A57 Link Roads

**9.13 Draft Statement of Common Ground
with Peak District National Park Authority**

9.13 DRAFT STATEMENT OF COMMON GROUND WITH PEAK DISTRICT NATIONAL PARK AUTHORITY

Table 3.2: Table of Issues/Matters - Final Version dated 6th January 2022.

**Fig 7.5 Indirect Representative Viewpoints within
Peak District National Park (PDNP)**

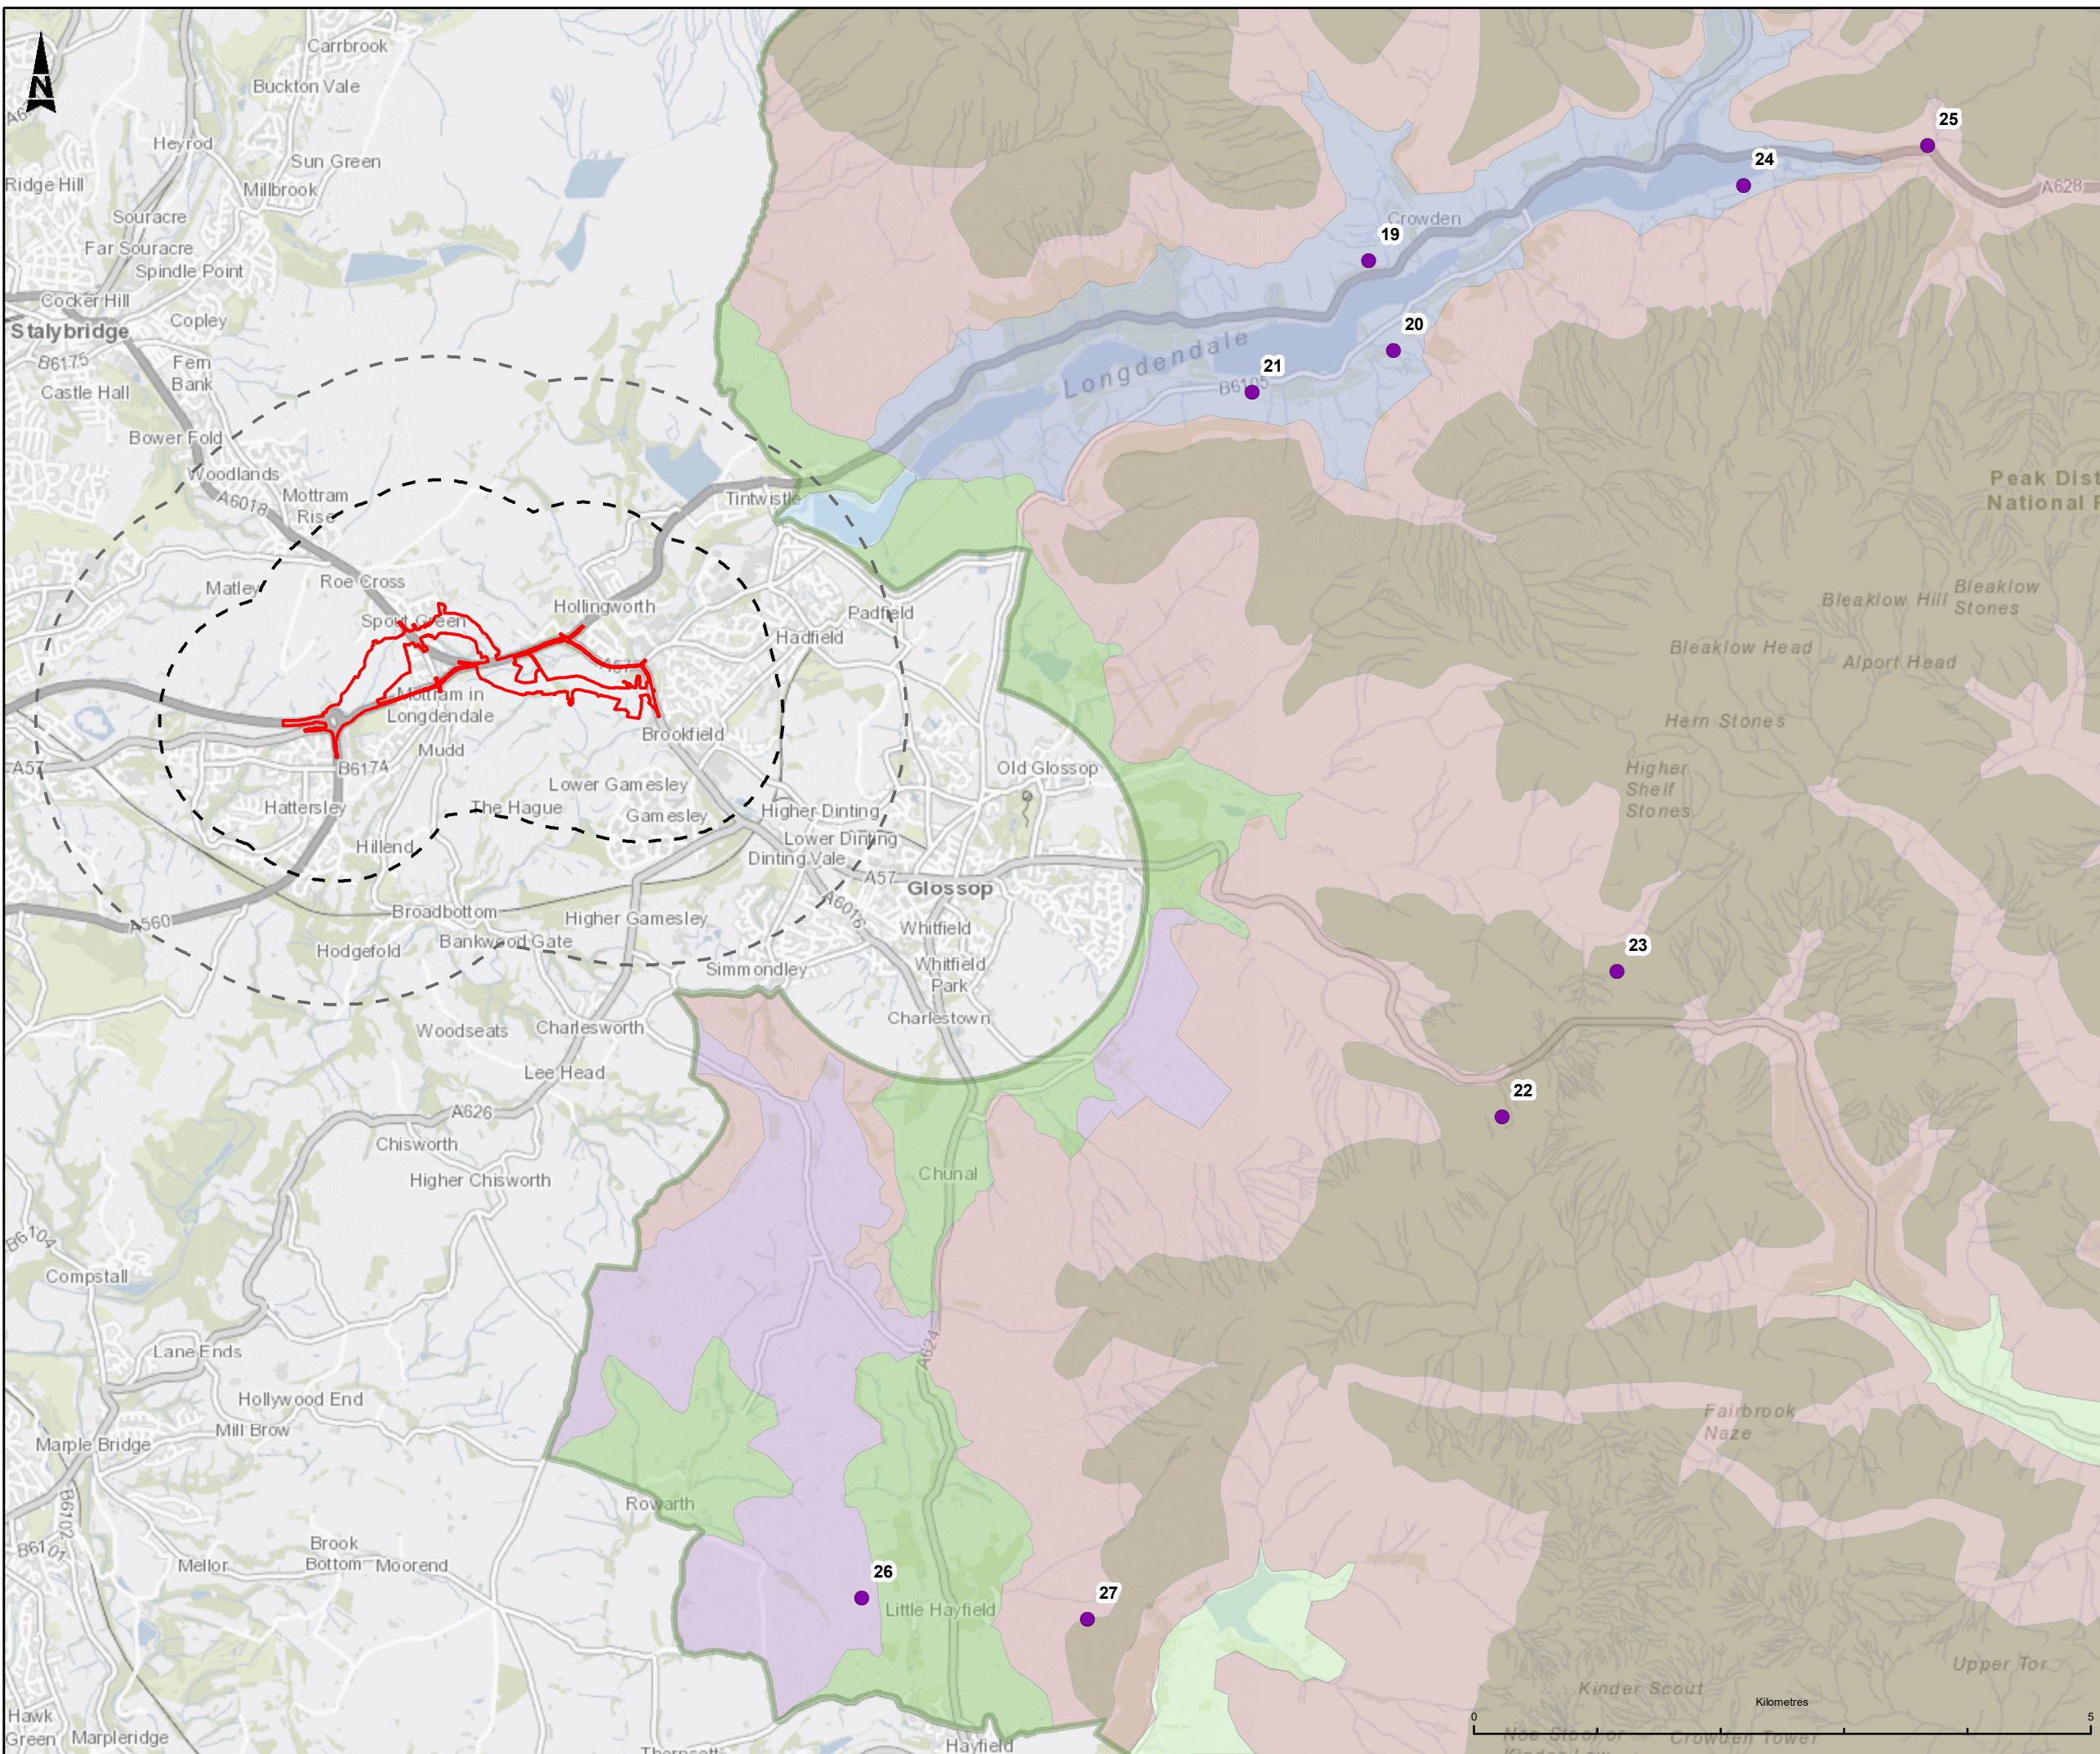
2.2.1.1	ES Chapter 7: Landscape and visual effects (APP-063)	Indirect landscape and visual assessment methodology	<p>Landscape and visual</p> <p>Following PDNPA request for additional Representational Viewpoints (VPs) the applicant requested confirmation of recommended VPs (email 21st August 2020). Email response confirmed 'subject to on-site verification for actual visibility the additional indirect representative VPs suggested are acceptable'</p> <p>Virtual meeting (9th Dec 2020): Further information is required as to how the impact on the PDNP been assessed.</p> <p>Virtual meeting (26th January 2021): PDNPA agree that the Scheme itself is located outside the park and don't think there will be any major direct effects so the main likely key landscape and visual effects will be indirect effects experienced as a result of changes to (a) traffic volumes, flows, peaks etc and (b) potential signage/highway upgrades on existing routes as a result of the increased traffic volumes). Would like to see clarification from the indirect assessment methodology regarding</p>	<p>The previous approach to the assessment of visual amenity had previously been generally accepted, however as there had been no formal acceptance, the PDNPA were contacted via email (dated 21st August 2020) to confirm the suggestion for the additionally requested representative viewpoints along the A624.</p> <p>Technical leads for the landscape assessment undertook a formal consultation with the PDNPA to agree the assessment of indirect effects in the Peak District National Park (PDNP) and following receipt of comments on the draft methodology (email dated 16th March). Indirect effects on perceptual / experiential effects on scenic beauty, tranquillity, wildness etc) were included within the assessment methodology, which list the Special Qualities of the PDNP. A Scheme Level Landscape Character assessment has been undertaken (Figure 7.3 (APP-092)). A summary of the traffic data (based on the traffic methodology) has been included in Chapter 7 with reader cross reference to the appropriate Appendix. If potentially significant effects were identified in the PDNP, off site measures, e.g. traffic calming, could be explored but that is not within National Highways control. Subsequently, no requirement for off-site mitigation measures has been identified in Chapter 7. It was also confirmed that all planting mitigation would have to be within the DCO boundary.</p> <p>National Highways response to PDNPA Relevant Representation (RR-0677-6) is contained in National Highways response to Relevant Representations (pg. 19 and 20 REP1-042) :</p>	Under discussion

2.3.4	ES Chapter 7: Landscape and visual effects (APP-063) Chapter 11: Noise and vibration (APP-067)	Effects on quiet enjoyment	From the PDNPA Relevant Representation (RR-0677-10): We have concerns regarding the effects of the scheme on the following: b) Effects on quiet enjoyment – existing traffic levels on the A628 Woodhead and A57 Snake Passes have a negative impact on the tranquillity of the surrounding open countryside, with traffic noise being a major feature. Increased levels of traffic along these routes will further reduce tranquillity, especially for those using the trails or footpaths that parallel or cross these busy roads (e.g. Pennine Way, Pennine Bridleway, Trans Pennine Trail (TPT)).	National Highways response to PDNPA Relevant Representation (RR-0677-10): Chapter 11: Noise and vibration of the Environmental Statement (APP-067) includes an assessment of road traffic noise levels from the A628 and A57 with the Scheme and impacts to users of footpaths within the PDNP (paragraphs 11.9.86 to 11.9.89). The modelled operation phase traffic flows on the A628 at Tintwistle and Woodhead through the PDNP were not predicted to cause a perceptible change in noise level in the short or long-term. The A628 is adjacent to the Trans-Pennine Trail and crosses the Pennine Way; impacts on these footpaths would be negligible from changes in traffic on A628. Traffic flows on A57 Snake Pass and A57 Snake Road, which cross the Pennine Way, would increase to give a perceptible noise increase in the short-term, however by the future year the increase would have a negligible impact according to DMRB LA 111 criteria. Therefore noise levels in these areas near the A57 would perceptibly increase in the short-term, and the impact would be limited to within approximately 10m of the road and not the entirety of the PDNP. Landscape receptors are landscape designations, Landscape Character Types, and parts of the A57, A624 and A628 within the PDNP. Indirect effects upon the PDNP resulting from increased traffic were assessed. Perceptual/experiential effects were included within the methodology. Paragraphs 7.3.39 and 7.3.40 of the ES (APP-063) consider the Special Qualities of the PDNP and tranquillity and wildness). There were no	Under discussion

SoCG Ref. Number	Relevant examination document	Relevant Issue	PDNPA comment	National Highways response	Status
				<p>significant residual effects on the landscape character areas/types within the PDNP during operation.</p> <p>Viewpoints 19-26 inclusive represent views from the Pennine Way/Pennine Bridleway/Trans-Pennine Trail within the Peak District National Park (PDNP). These were set out in Chapter 7 Landscape and Visual Effects of the Environmental Statement (APP-063) Table 7.29 Indirect Effects. This recognises that traffic numbers will increase for the A57 and A628 (within the PDNP) and decrease for the A624 (within the PDNP) but that for all routes the magnitude of change of increased/decreased traffic, based on the existing scenario (whereby existing traffic affects the perception of wildness and tranquillity (the PDNP's Special Qualities)), was not high enough to result in significant effect greater than slight adverse for visual receptors on these routes.</p>

SoCG Ref. Number	Relevant examination document	Relevant Issue	PDNPA comment	National Highways response	Status
				<p>Viewpoints 19-26 inclusive represent views from the Pennine Way/Pennine Bridleway/Trans-Pennine Trail within the Peak District National Park (PDNP). These were set out in Chapter 7 Landscape and Visual Effects of the Environmental Statement (APP-063) Table 7.29 Indirect Effects. This recognises that traffic numbers will increase for the A57 and A628 (within the PDNP) and decrease for the A624 (within the PDNP) but that for all routes the magnitude of change of increased/decreased traffic, based on the existing scenario (whereby existing traffic affects the perception of wildness and tranquillity (the PDNP's Special Qualities)), was not high enough to result in significant effect greater than slight adverse for visual receptors on these routes.</p>
